1 RESTROOM: PLAN SECTION
 Scale: 3/4"=1'-0"

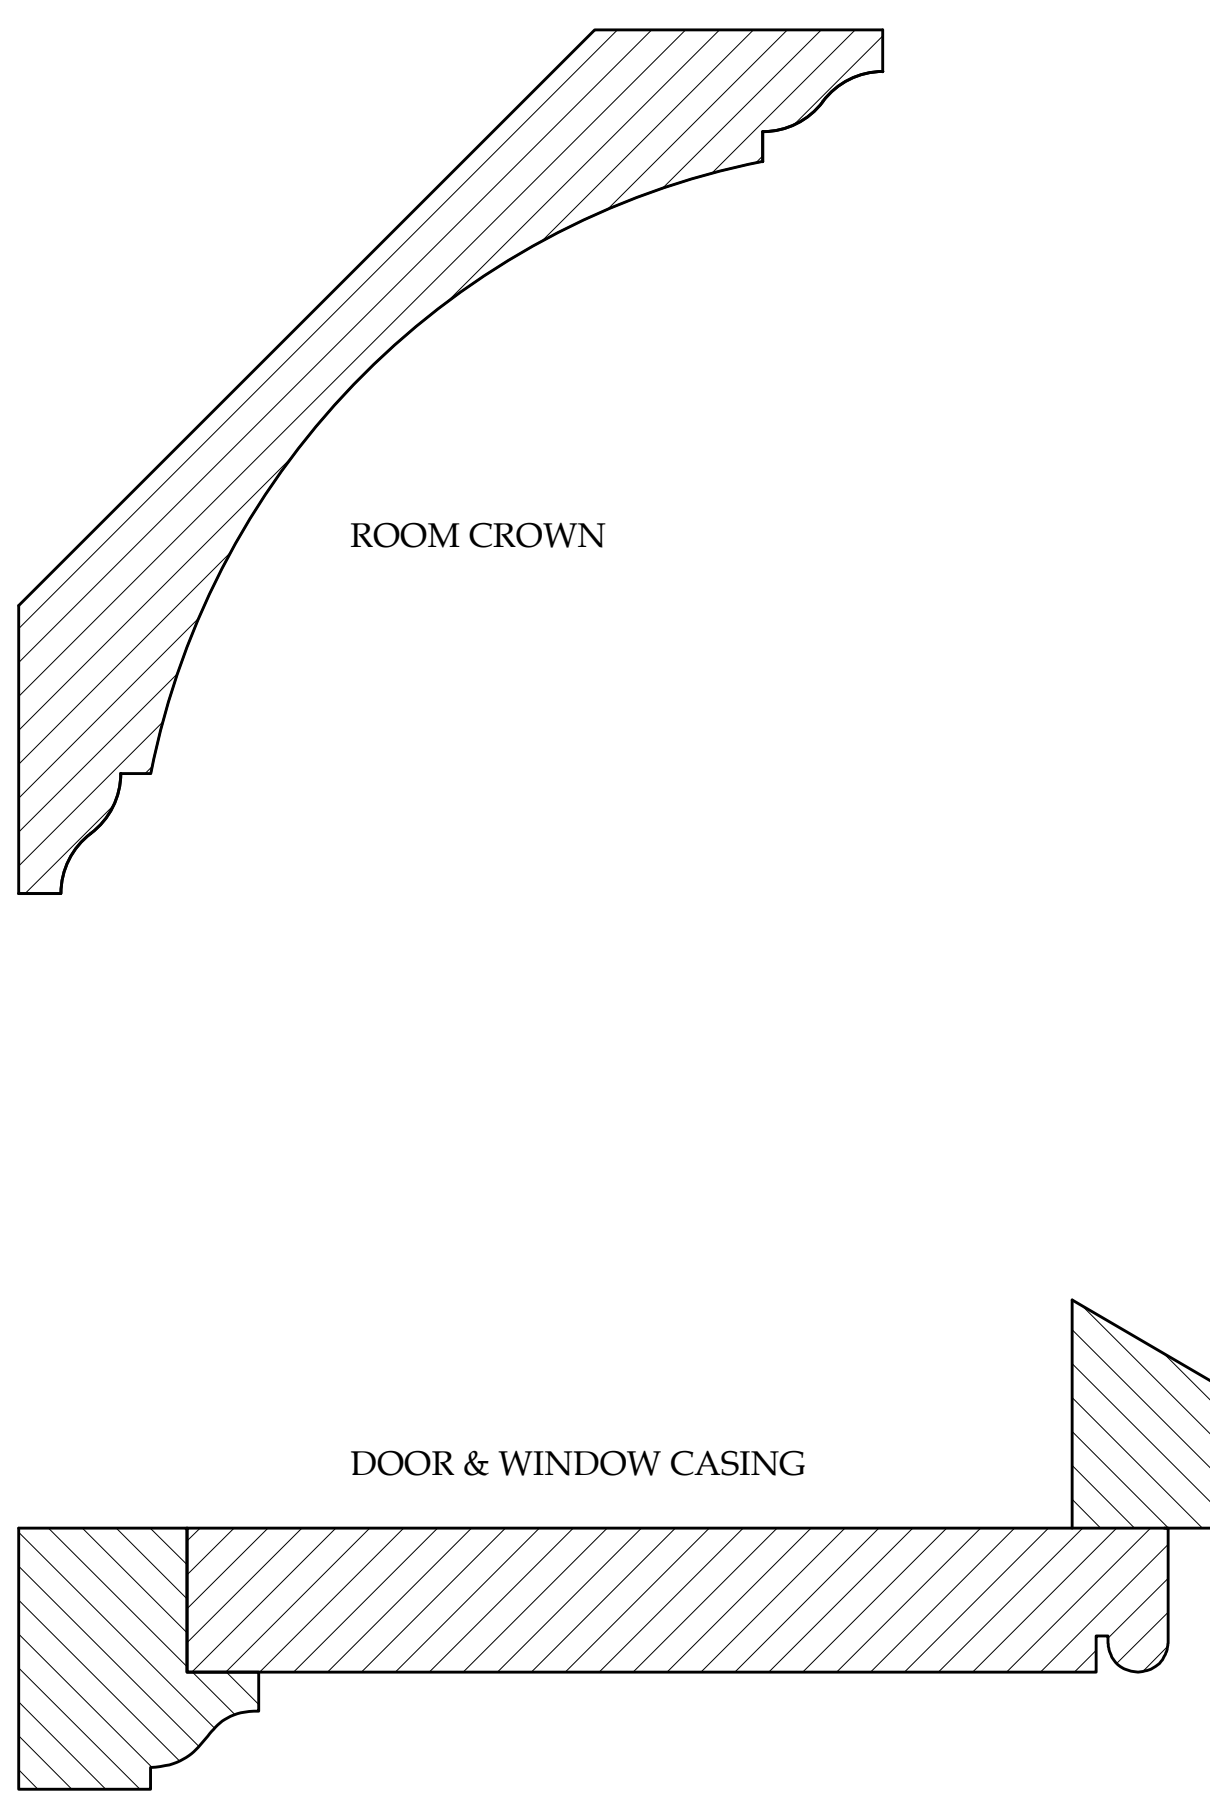
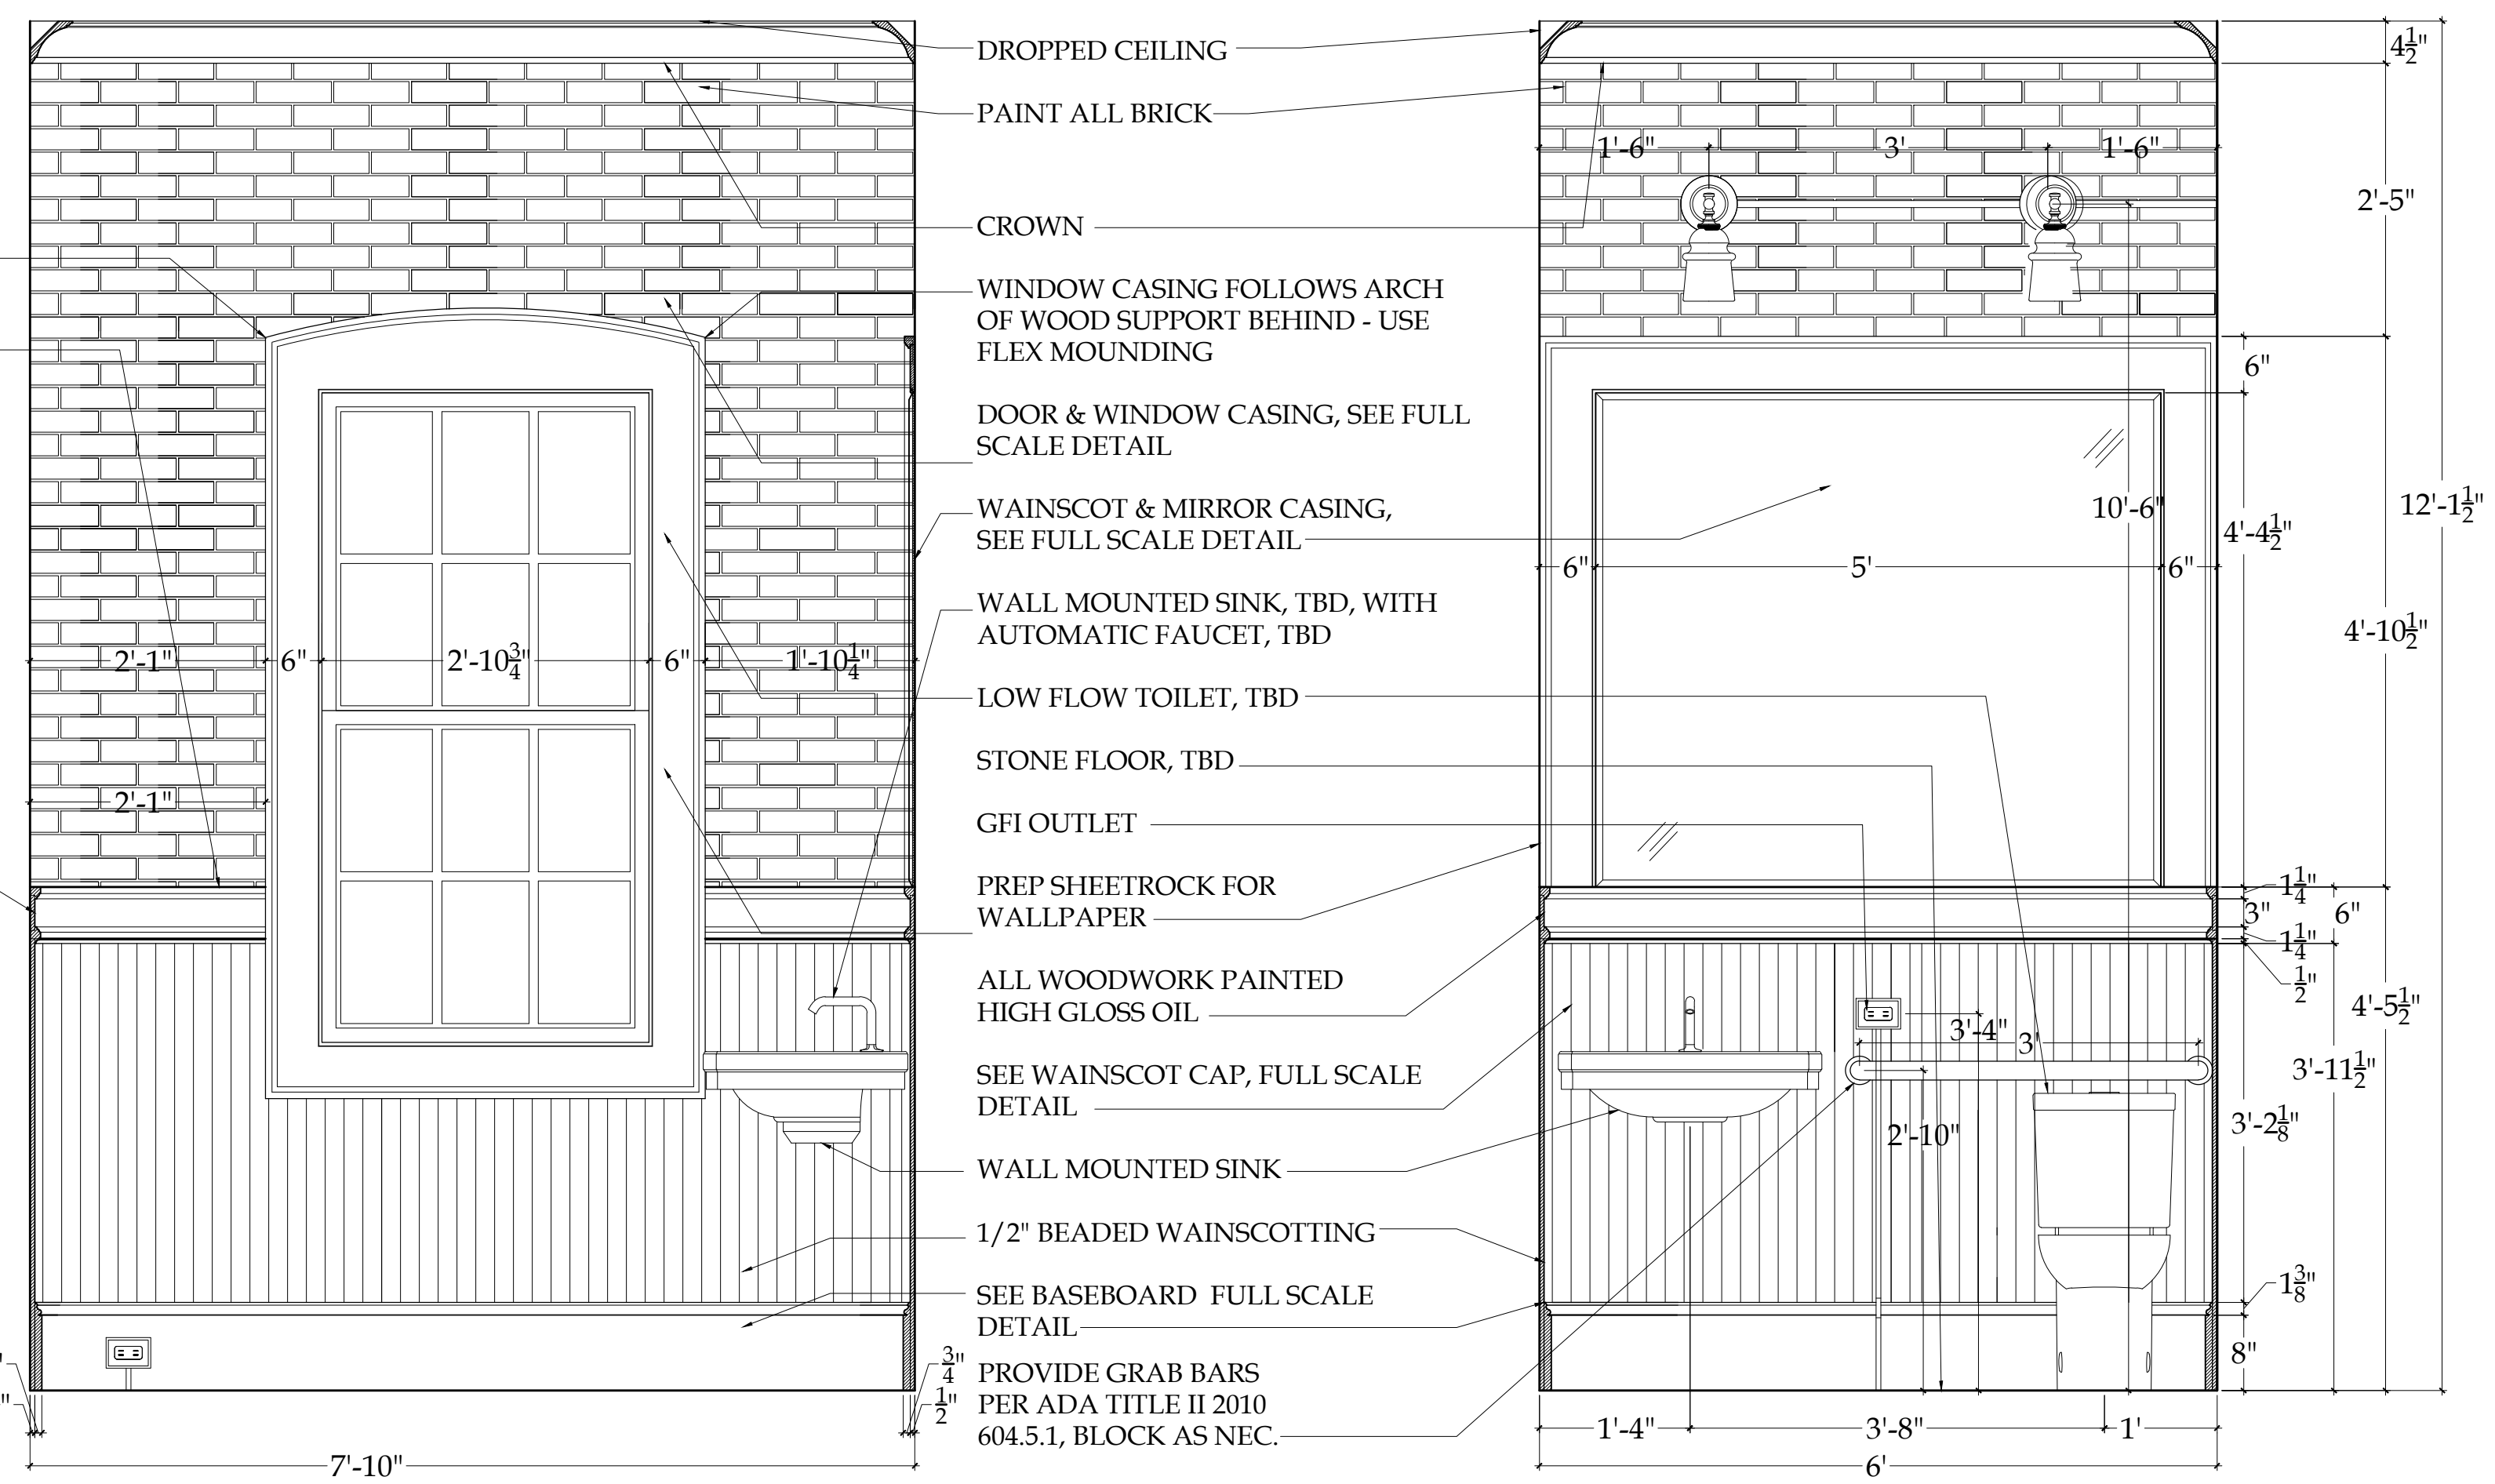
Please show 2010 ADA Standards compliance with clearances, grab bars and accessories.
